TfNSW reference: WST24/00054 | SF2024/037669 | WST23/00079
Your reference: SSD-33964533

SSD-33964533 – Goulburn River Solar Farm – Response to RFI

This attachment relates to TfNSW's response dated 7 May 2024 reference WST24/00054.

GOULBURN RIVER SOLAR FARM
GOLDEN HIGHWAY / BARNETT STREET
INTERSECTION
80% DETAILED DESIGN
CIVIL ENGINEERING DRAWING

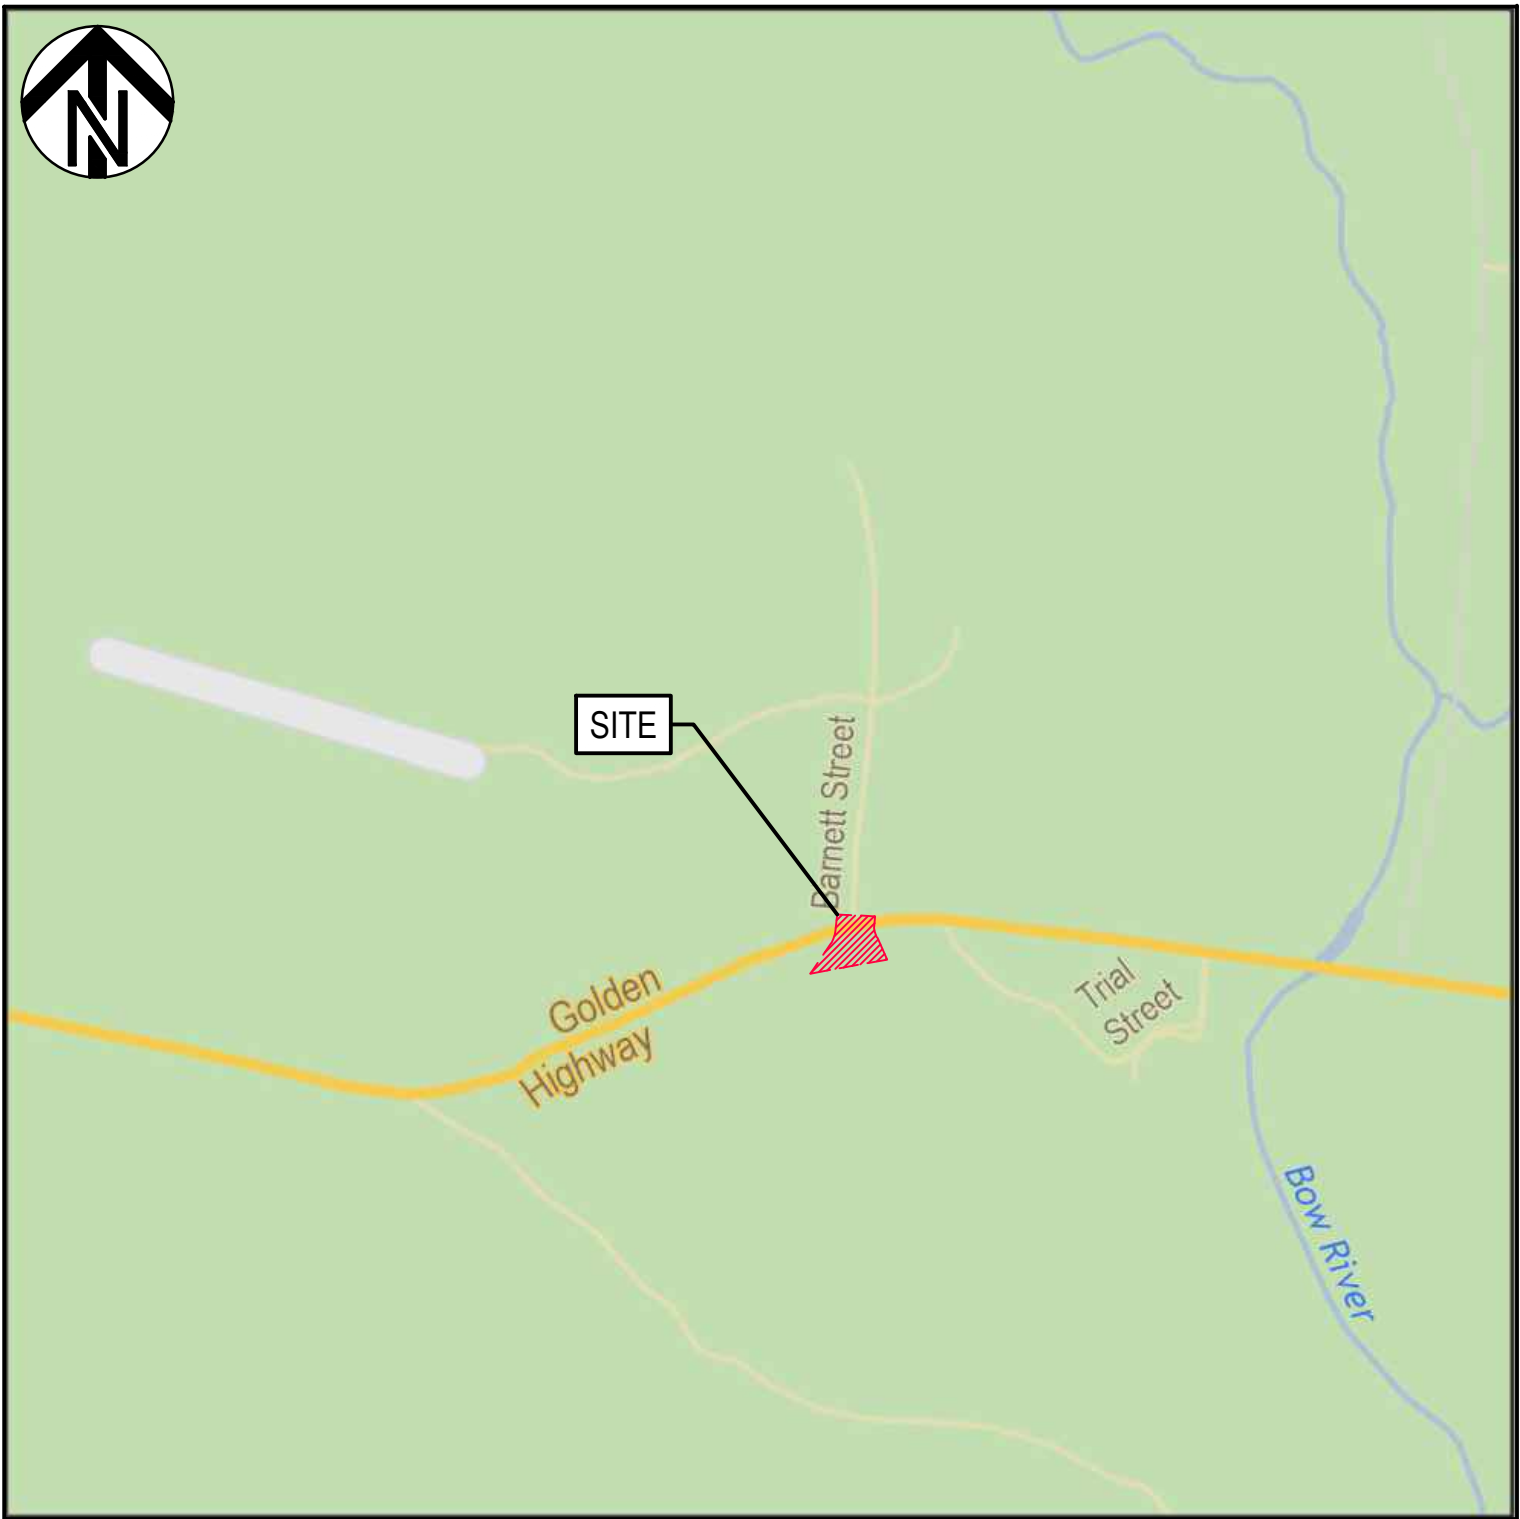
1. Barnett Street is required to be sealed at the throat of the intersection with Golden Highway. This is to reduce the amount of gravel being carried onto Golden Highway.
2. Advanced warning signage, including trucks turning signs, to the satisfaction of TfNSW is required on both approaches to this intersection along Golden Highway.
3. A complaints section within the TMP will be required to address any concerns raised during construction of the development.
4. Ensure owners consent is provided for use of the run around facility on Barnett Street.
5. Require signage to ensure that the turn around facility is clear for the construction traffic vehicles associated with the Goulburn River Solar Farm.

**Figure 4 | Vehicle movement restrictions at Golden Highway / Ringwood Road Intersection**

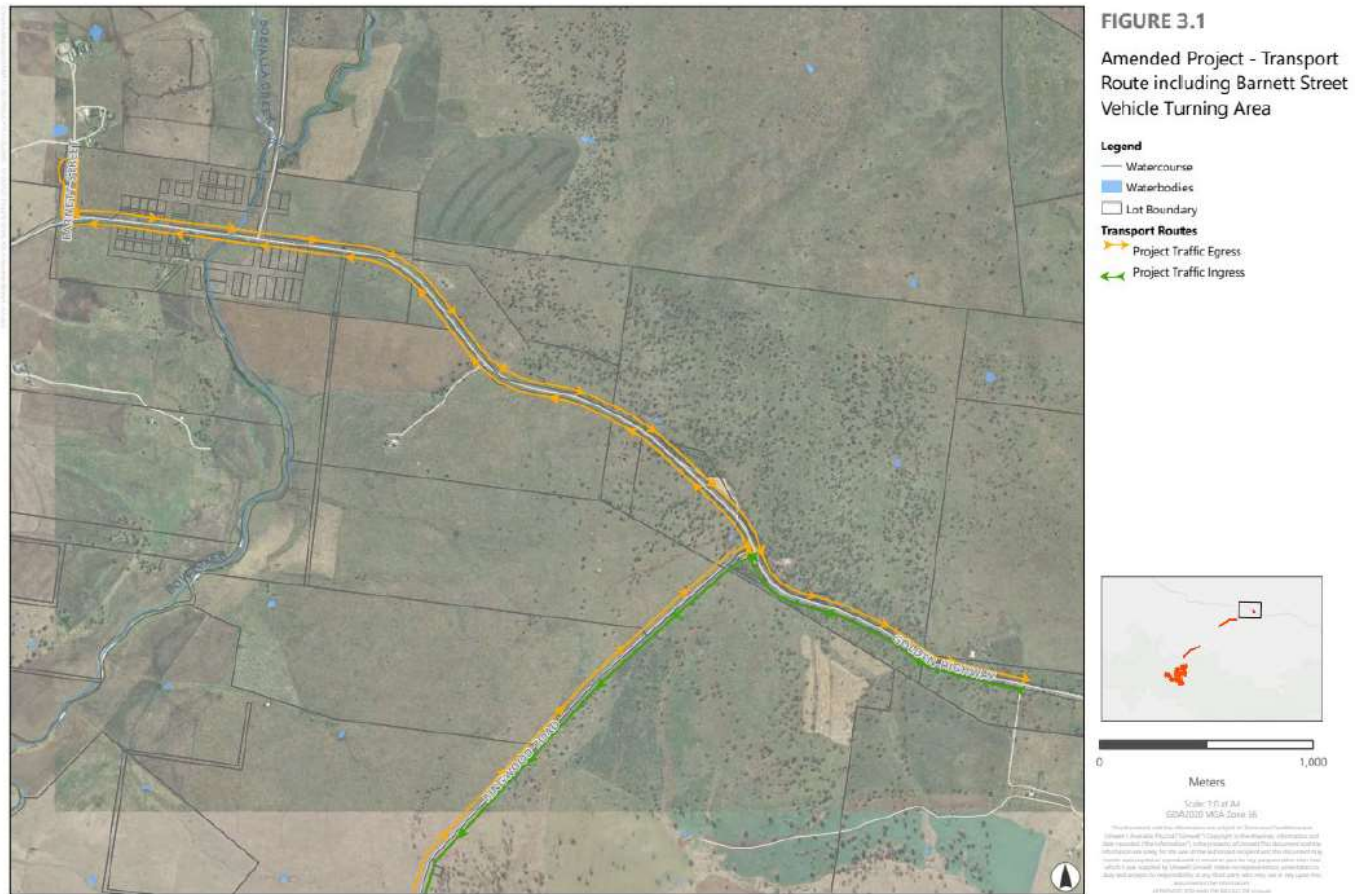
2. The proponent will be required to enter a Works Authorisation Deed (per s64 of the Roads Act 1993) for s138(2) *Roads Act 1993* approval.
3. A condition will be required to identify the left in and left out movement for construction traffic and prohibition of the right in and right-out movements for construction traffic.
